**Western Sydney University – Innovation Hub, 2-6 Hassall Street, Parramatta (SSD 9670)  
Notice of Exhibition**

The relevant documents within the Environmental Impact Statement have been reviewed and comments are provided in **Attachment A**.

## **Attachment A: Comments on Western Sydney Innovation Hub**

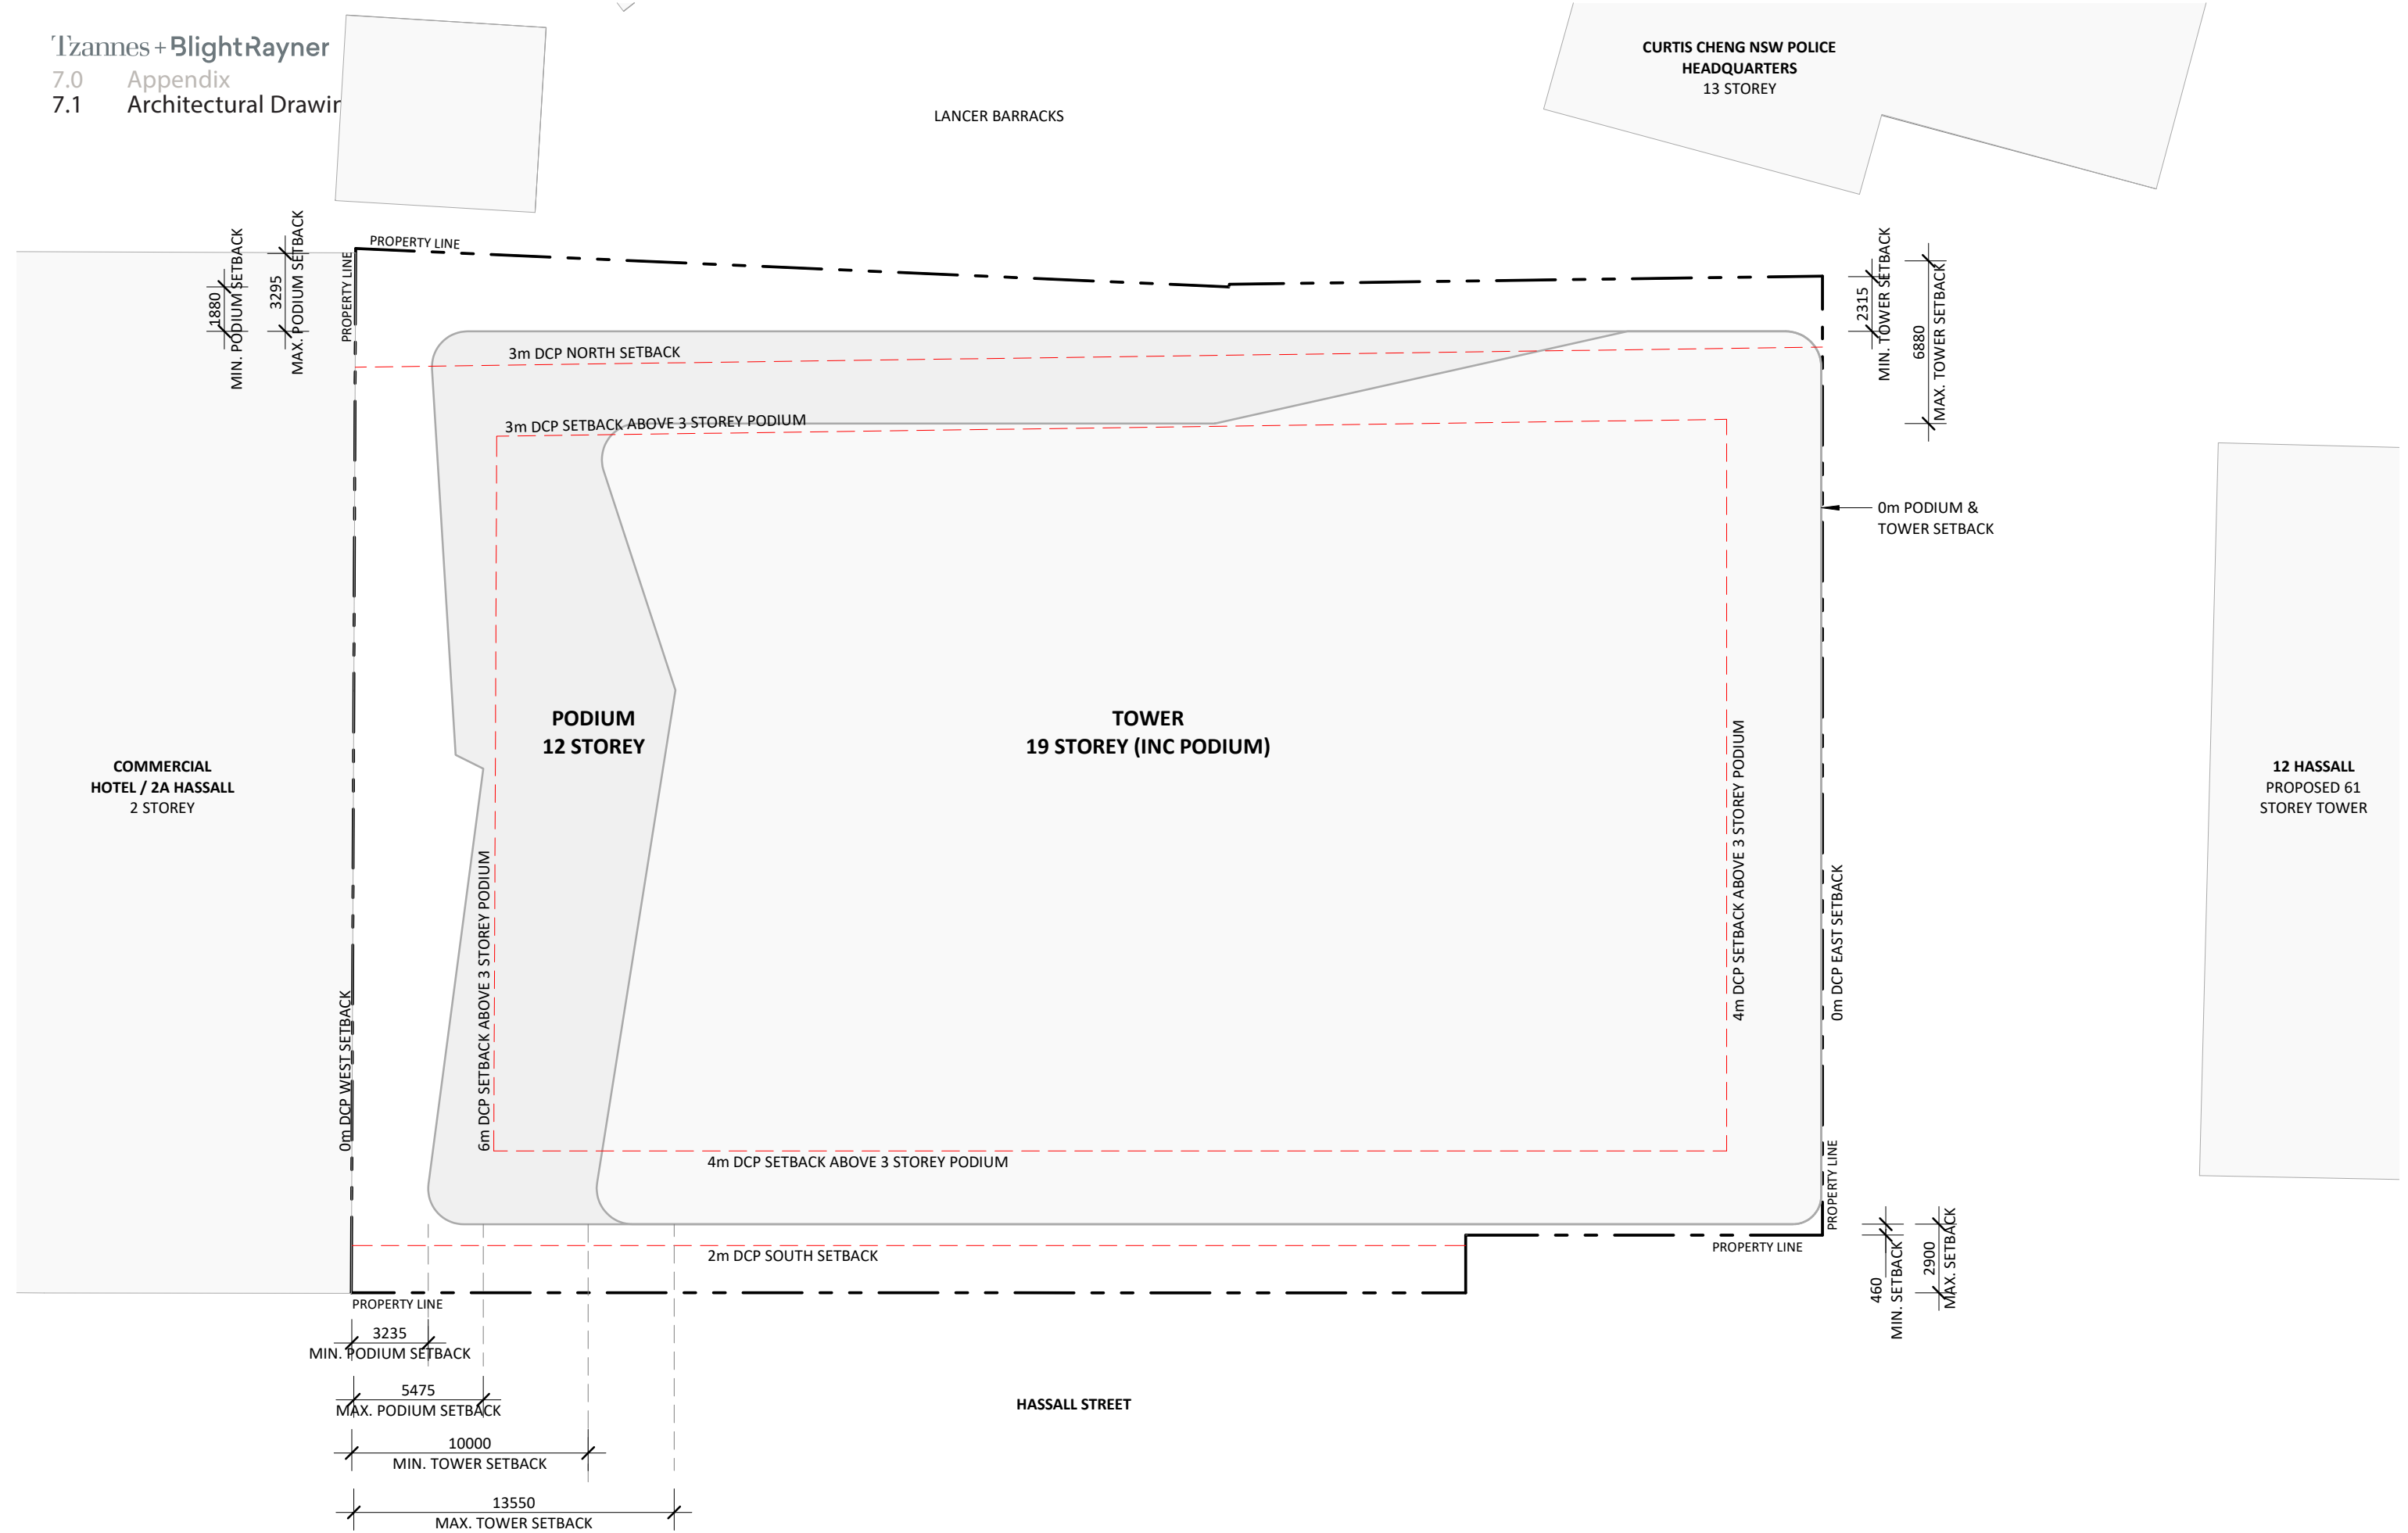
The proposal includes two Small Rigid Vehicle (SRV) bays to service the building and the traffic assessment notes that this is based on the provision of two SRV spaces for the existing WSU building at 1 Parramatta Square (1PSQ). Two SRV spaces are potentially insufficient for a building of 30,440m<sup>2</sup> GFA whereby more than 13,000m<sup>2</sup> is dedicated to retail/commercial uses.

Comparisons with the facility at 1PSQ could underestimate the loading facility demands for the subject site as the 1PSQ facility will be part of a precinct facility for the whole of Parramatta Square and not as a standalone facility.

It is recommended that the Applicant provides an assessment of the projected freight and servicing movements (number and type by day) and a draft management plan to better understand the requirements for freight and how these movements would be managed.
